Your Ref	SSD-34919690-Mod-2
Our Ref	NCA/3/2022
Contact	Douglas Bennett
Telephone	02 9806 5405
Email	dbennett@cityofparramatta.nsw.gov.au

04/12/2024

**COUNCIL SUBMISSION TO REQUEST FOR ADVICE ON MODIFICATION REPORT –
NOVUS ON HARRIS AT 39-43 HASSALL STREET, PARRAMATTA**

APT. TYPE 2A - PRE ADAPTED

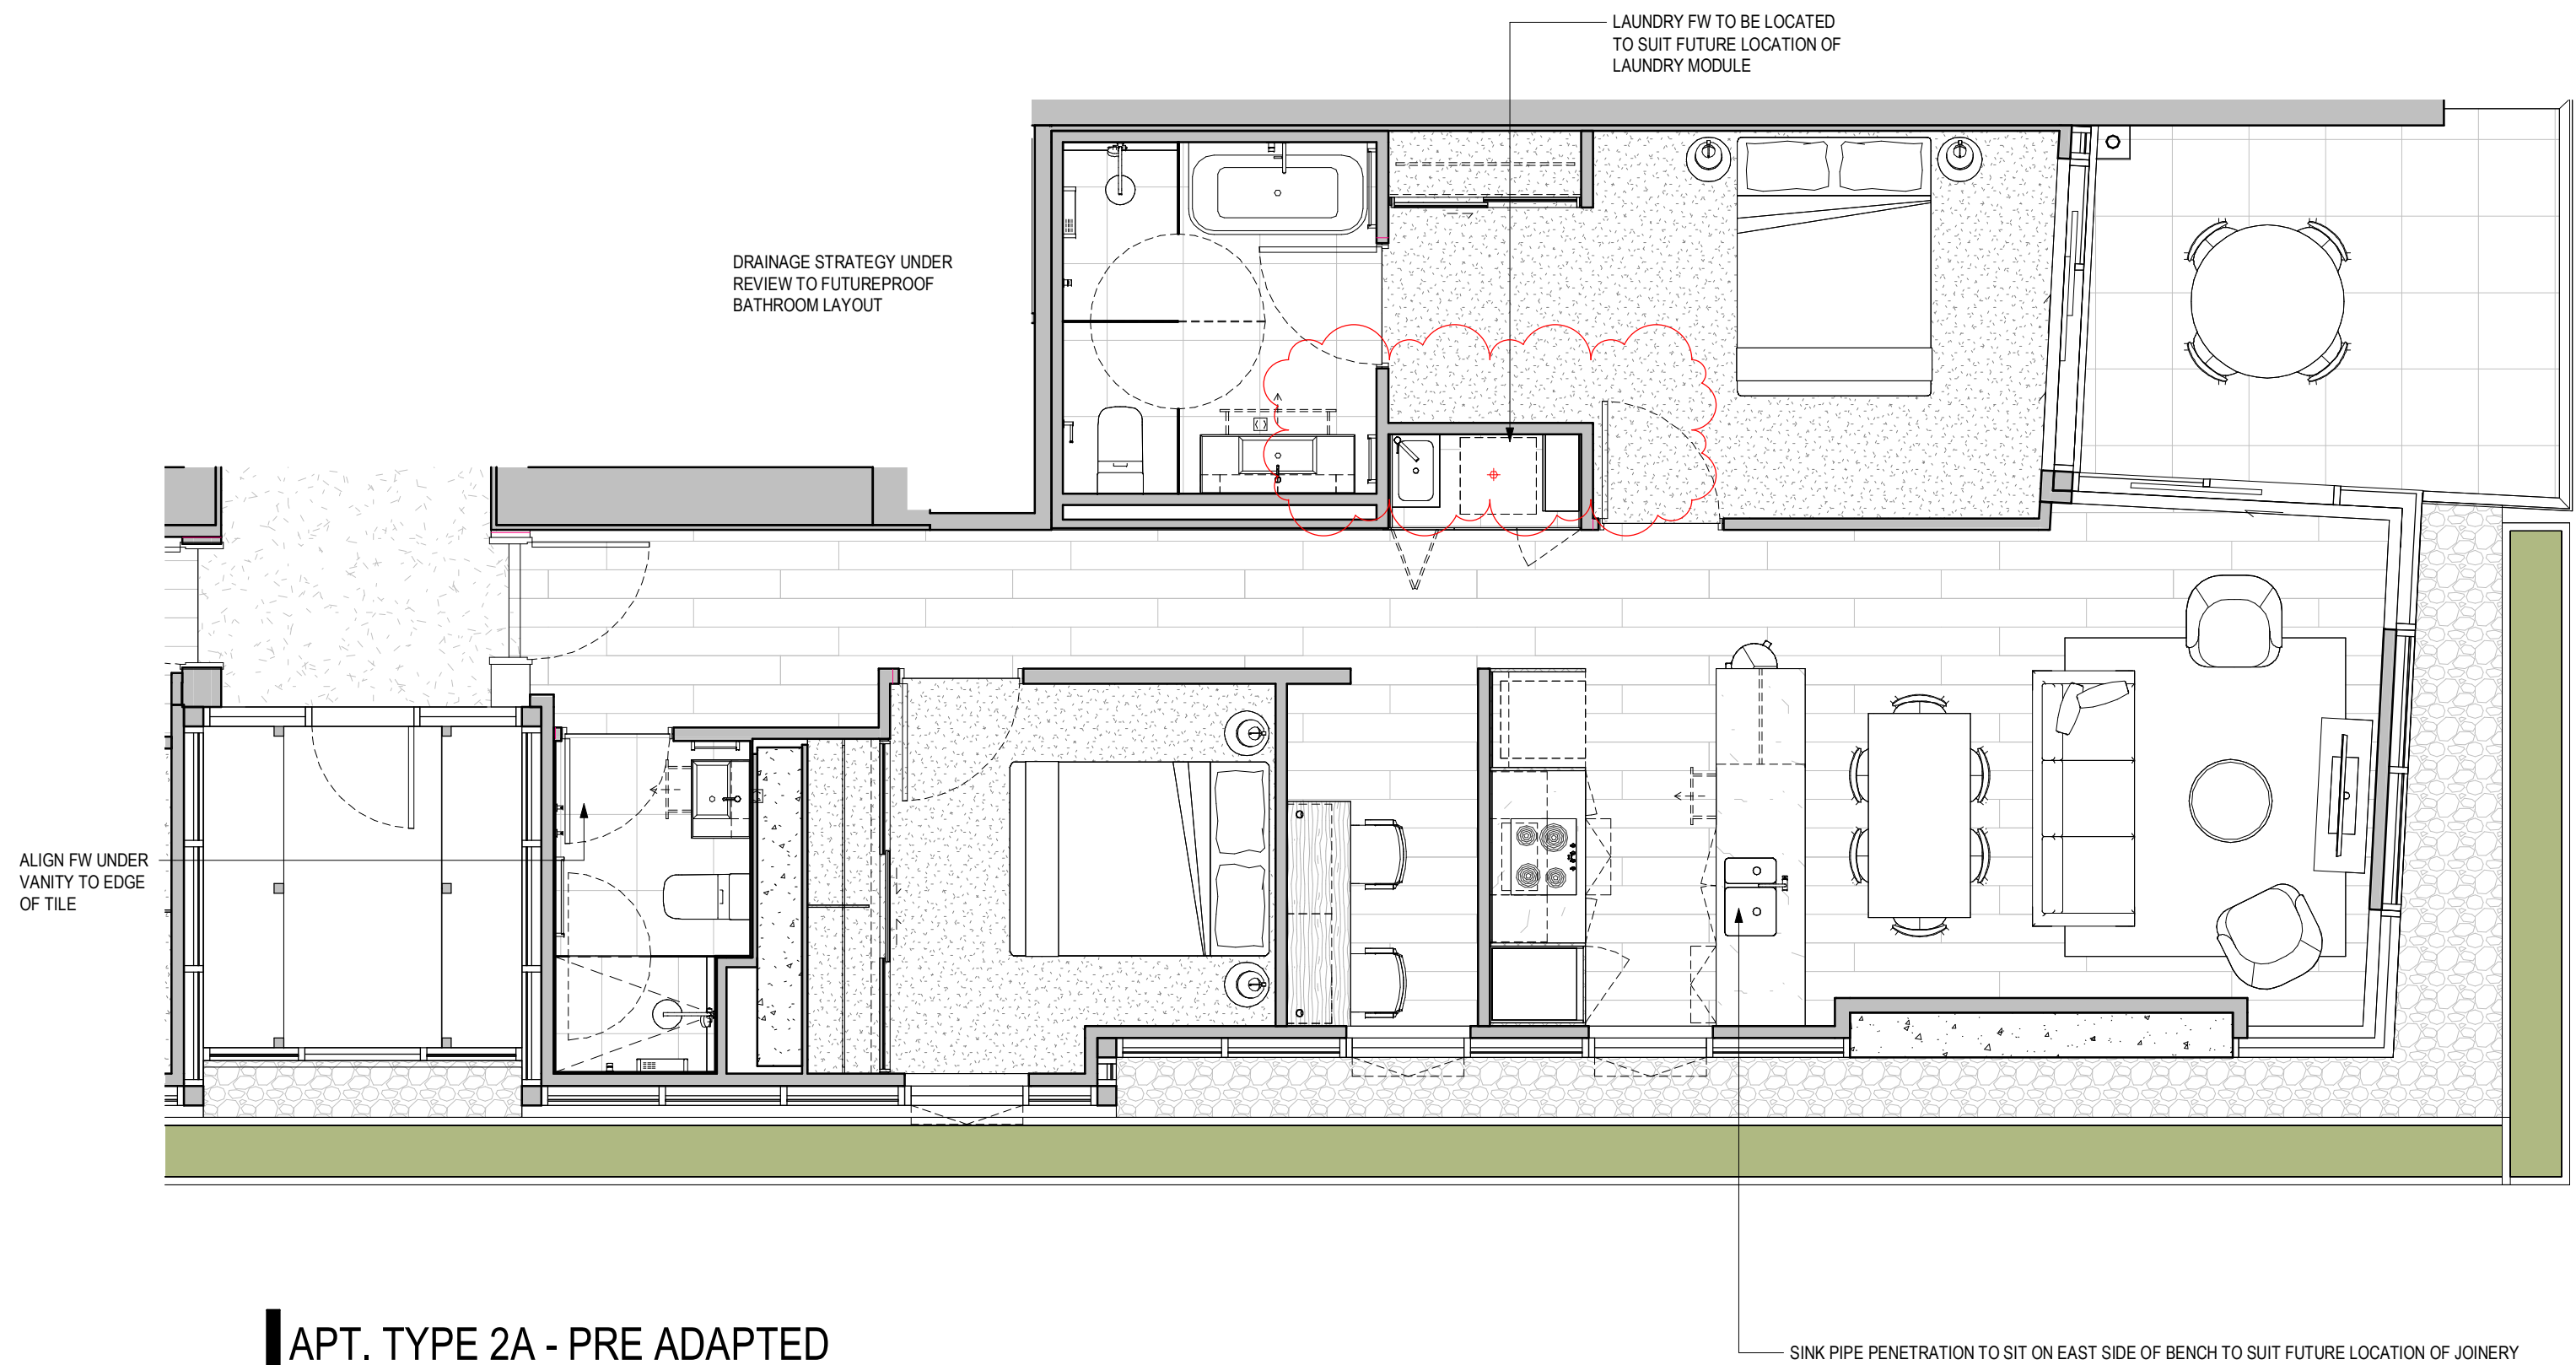
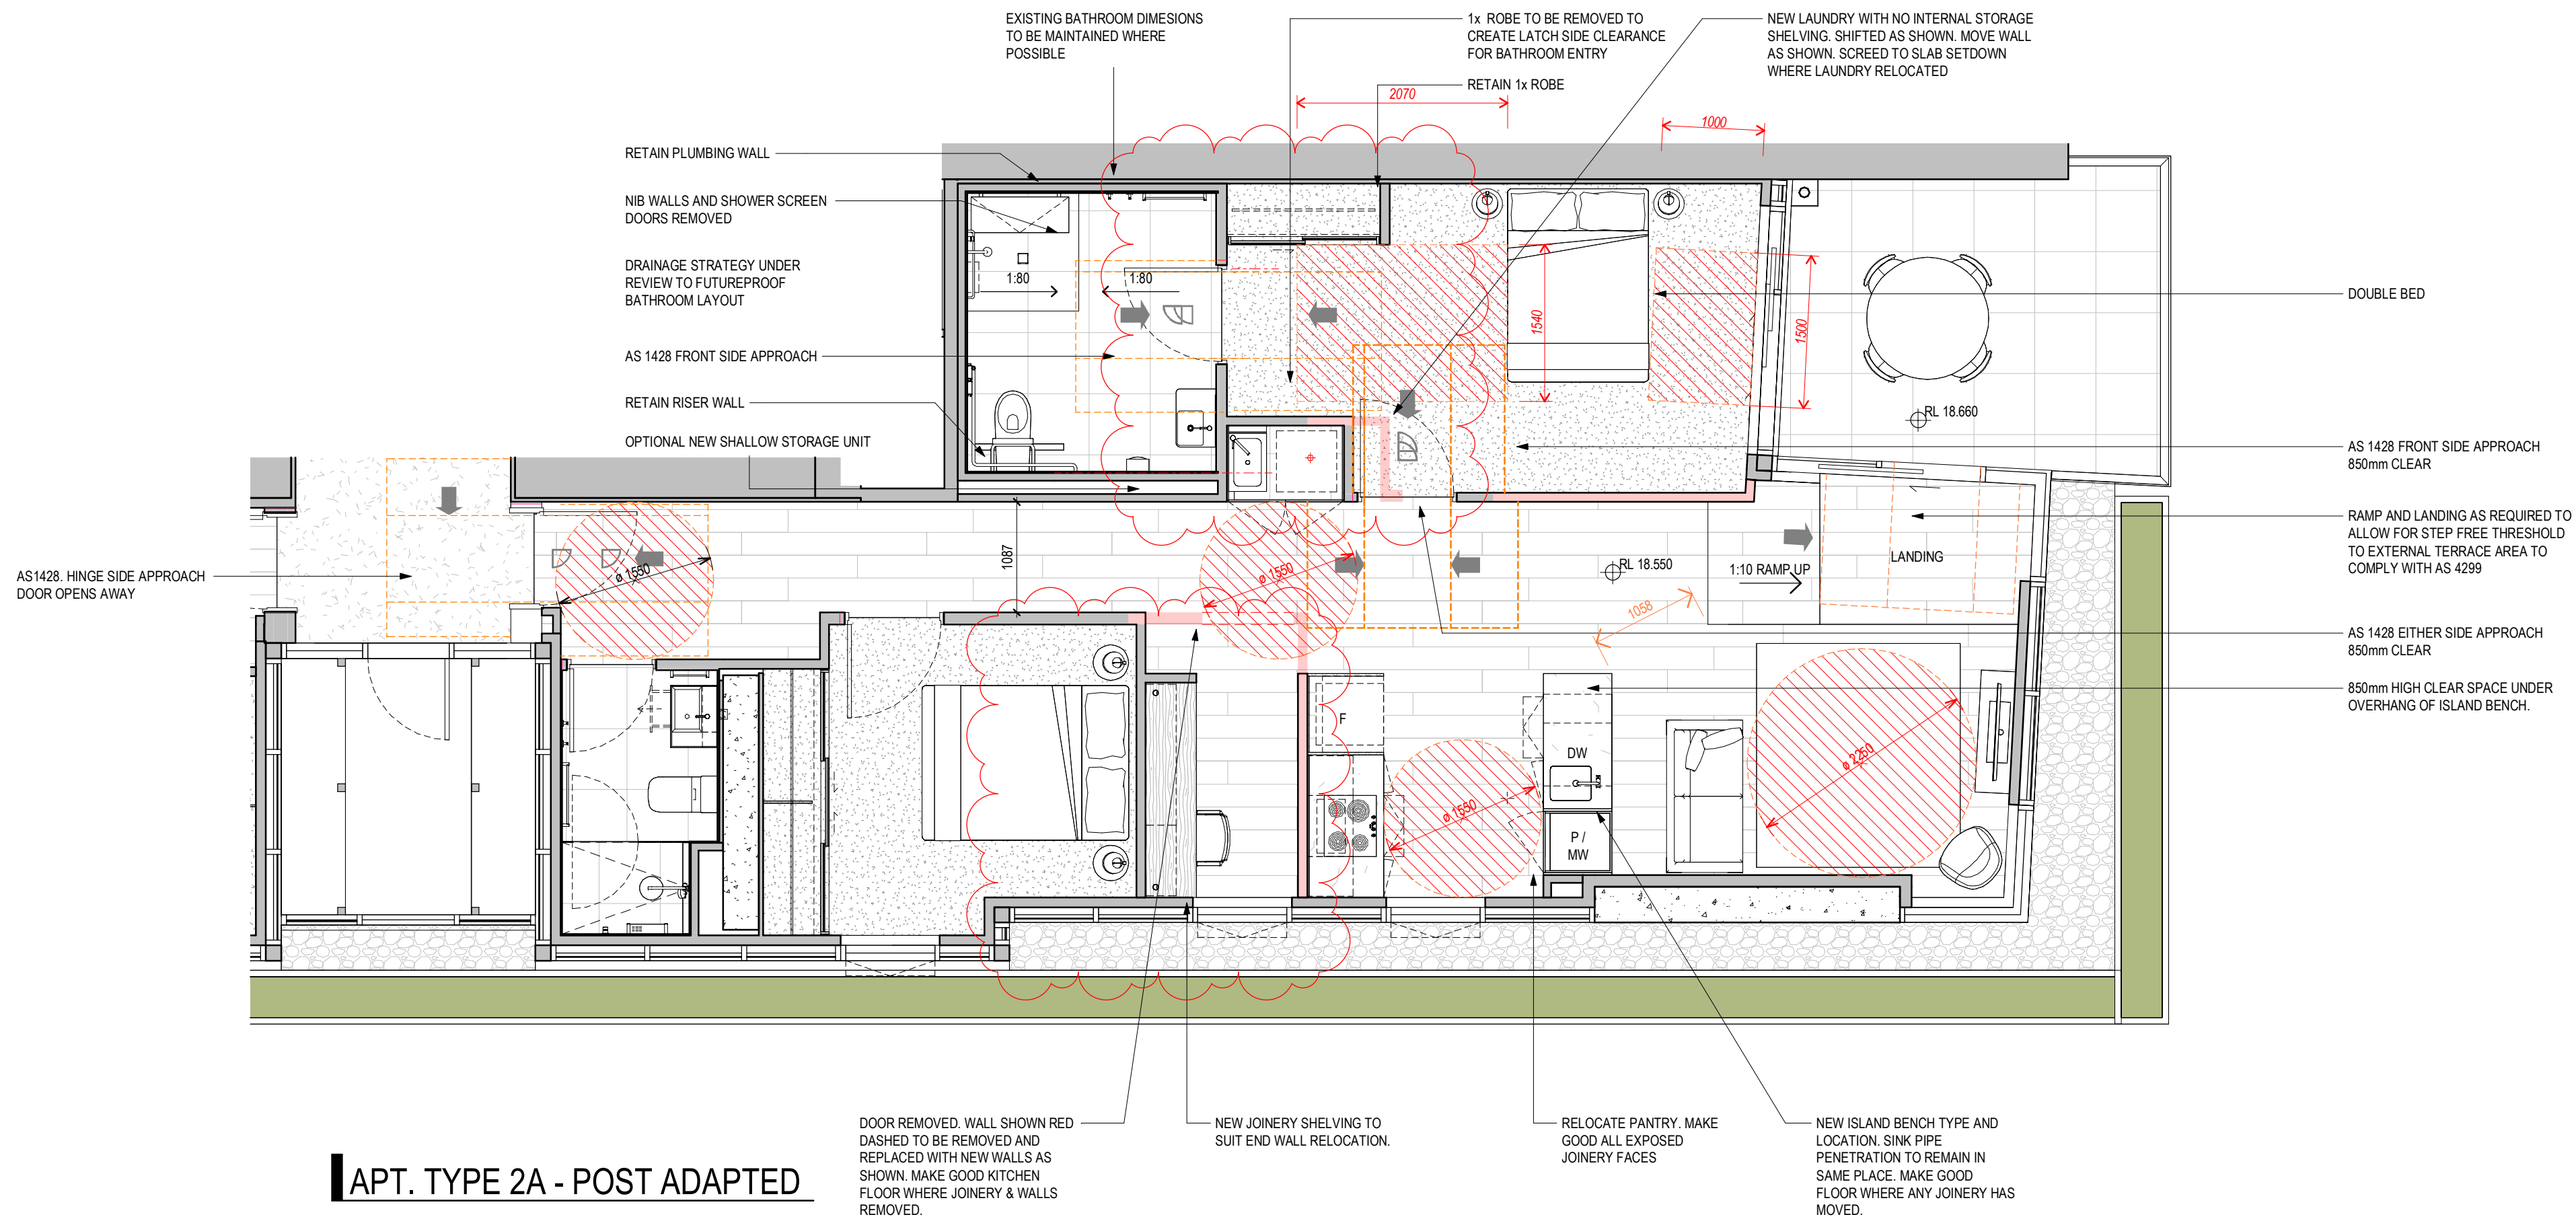
Significant changes to unit 2A have been proposed. The works required to convert this unit to a post-adaptable state are inconsistent with the principles of AS 4299 which requires adaptable housing to be adapted at relatively little extra initial cost at minimum inconvenience. Council notes the following works are required to convert this unit to its post adaptable state:

- Reduction of the laundry size – the post-adaptable state requires the reduction in the size of the laundry and partial demolition of laundry walls. The works also require the relocation of the bedroom door which is impractical and inconsistent with the principles of AS 4299. This is not ideal.

- Reduction of storage areas – the post-adaptable state requires the deletion (and loss) of storage space in the study area. This is not ideal.
- Reduction of study area – insufficient circulation space has been provided to the study area in the post-adaptable state. This is not ideal.

- Reduction of kitchen – the post adaptable state includes a reduction in benchtop surface area in the kitchen, eliminating the required preparation areas required in AS 4299. This is not ideal.

- Reduction of size of the living area to provide ramps up to the outdoor balcony. This is not ideal.
- Deletion of dining room table – no dining room table is provided in the post-adapted state. This is not ideal.

Section A | South Western Jetty Over Riparian Zone

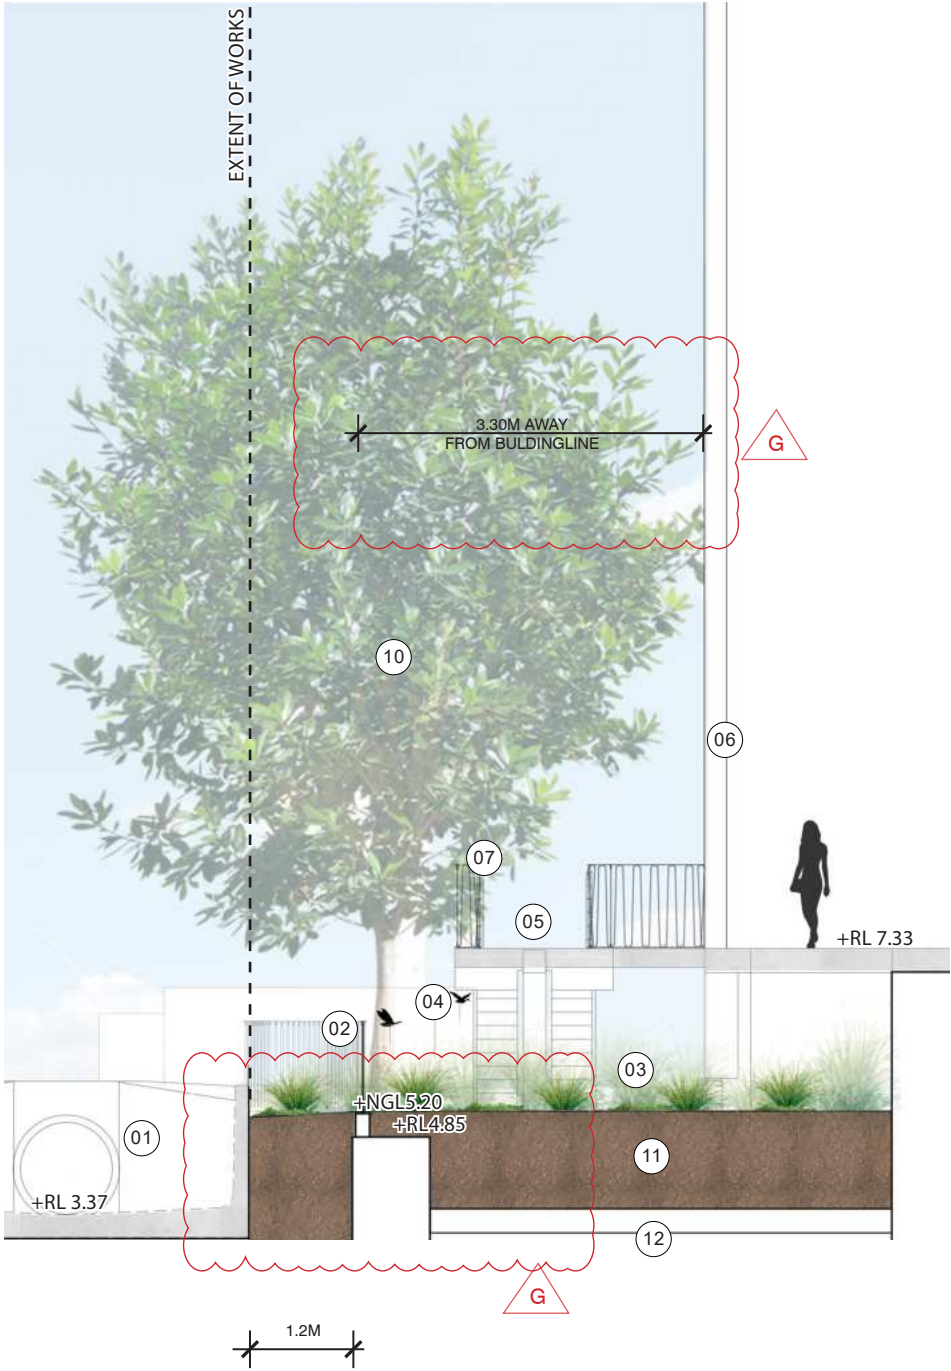
- Section A of the landscape report does not show the basement structure only 1.2m from the boundary extent, below the proposed planting strip/riparian zone.
- Planting on structure details are to be provided showing substrate depth, drainage, waterproofing for all planting on structures, including planting over the basement at ground level.
- Soil volume, depth and soil areas on podium and over the basement must meet the following prescribed standards in the Apartment Design Guide (ADG) – Part 4, 4P *Planting on Structures – Tools for improving the design of residential apartment development* (NSW Department of Planning and Environment, 2015):
 - Typical tree planting on structure detail to show overall 800-1200mm soil depth.
 - Soil volume to be reflective of proposed tree species size.

Section B | Harris St Setback

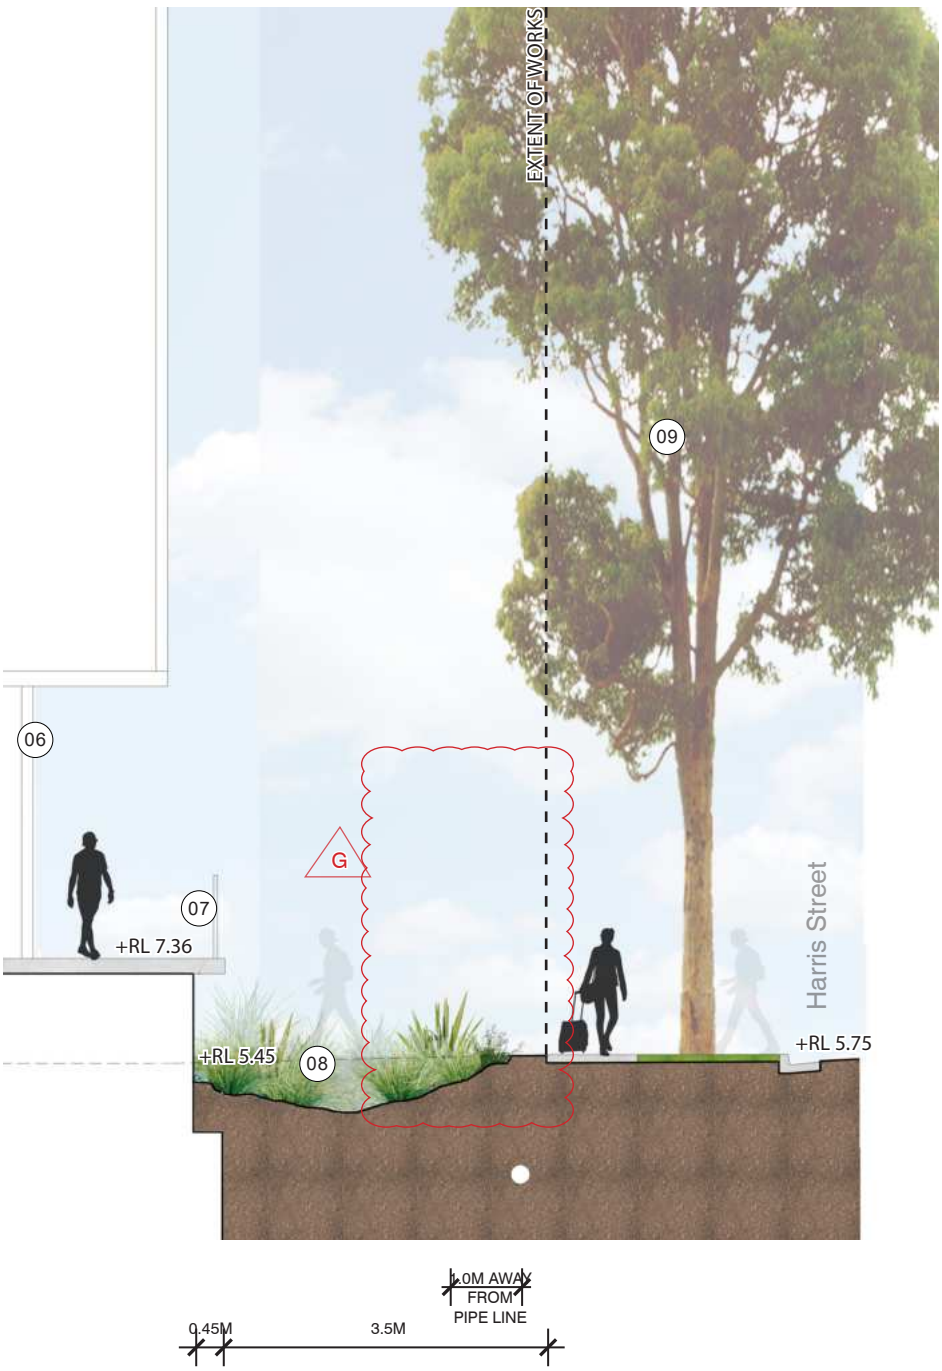
Council has reviewed the revised landscape report for the modification application and raises concern over the location of 4 x *Tristaniopsis laurina* (Watergum) trees, at ground level, that are shown to only be planted between 0.45-0.5m away from the approved building. This is not considered to be ideal. The proximity to the building means the trees will clash with the building façade, causing on-going building maintenance issues. Constant pruning will be required, resulting in the poor form, structure and overall decline of the proposed trees. The likely outcome of this will be the eventual removal of the trees from the site.

Section B of the application's accompanying landscape report incorrectly illustrates the location of *Tristaniopsis laurina* and shows the tree as clashing with the building façade (see figures below).

- All trees at ground level are to be relocated a minimum 3m away from the edge of the building. Detail is to be provided in an amended report.
